### Submission Form

**Epping to Thornleigh Third Track Proposal.** Application number SSI 5132.

I/we object to the Epping to Thornleigh Third Track Proposal and consider that the EIS is inadequate and does not address the full impact of this proposal. It will cause untold damage to the health of residents and to the fabric of the Beecroft Cheltenham Heritage Conservation Area. Do not approve this project, reconsider the alternatives and protect the community.

Figure 5.6 Cross-section and elevation - New Cheltenham Station concourse building
Note: Indicatively added to future design

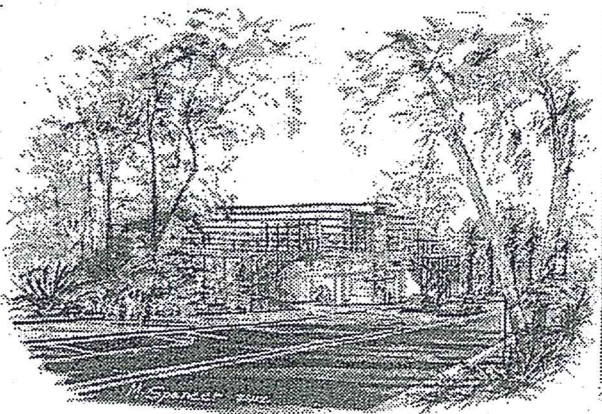
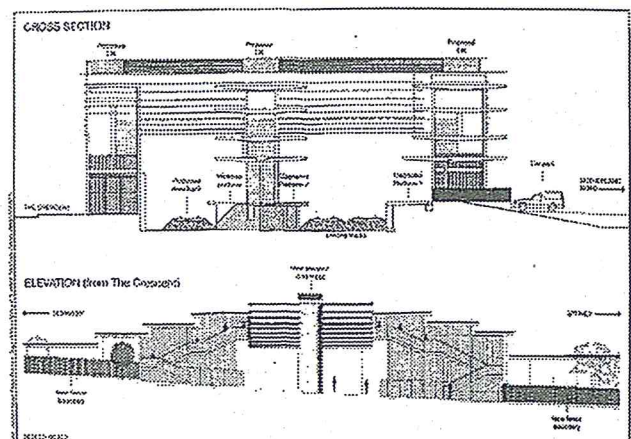
- The proposed redevelopment of Cheltenham Station shows no regard for the HCA. The visual impact of the proposed 13m high glass and steel concourse is totally unacceptable in this HCA.

Concept design drawing of proposed changes to Beecroft Station (Parsons Brinckerhoff 9/3/12). Former side platform shaded in pink.

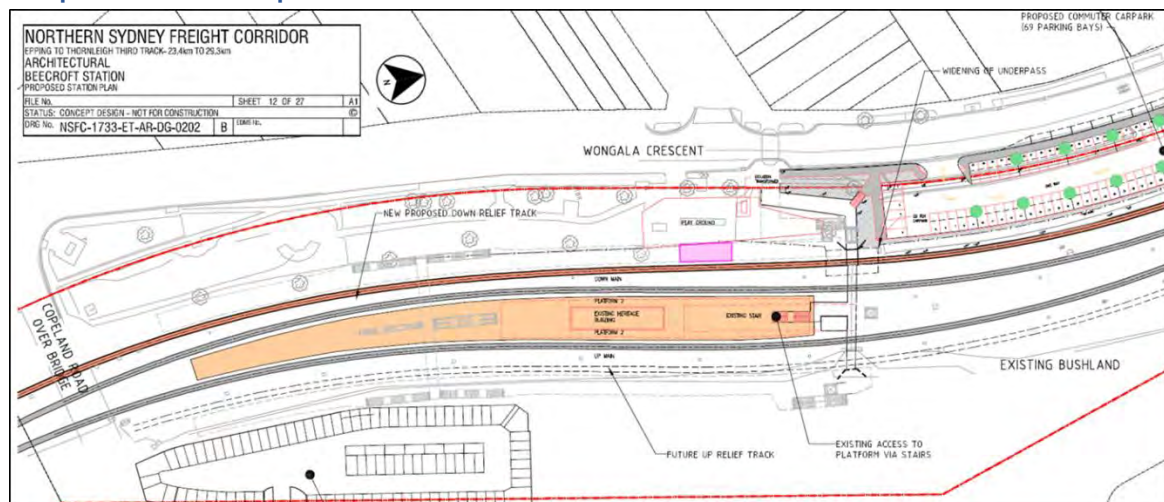
- There has been inadequate assessment of the project's impact on the fabric of the Beecroft Cheltenham Heritage Conservation Area (HCA).
- The plan given for Beecroft Railway station Precinct is vague. The relationship to the trees, playground and original 1895 platform located south of the present station is not shown. A fourth track is shown on the eastern side. The plan does not include urgently needed lifts to allow disabled access at Beecroft Station.

- Beecroft Station Gardens have a heritage listing with Hornsby Council but the impact on them has not been adequately addressed. No arborist's report is given for the trees which will be removed.
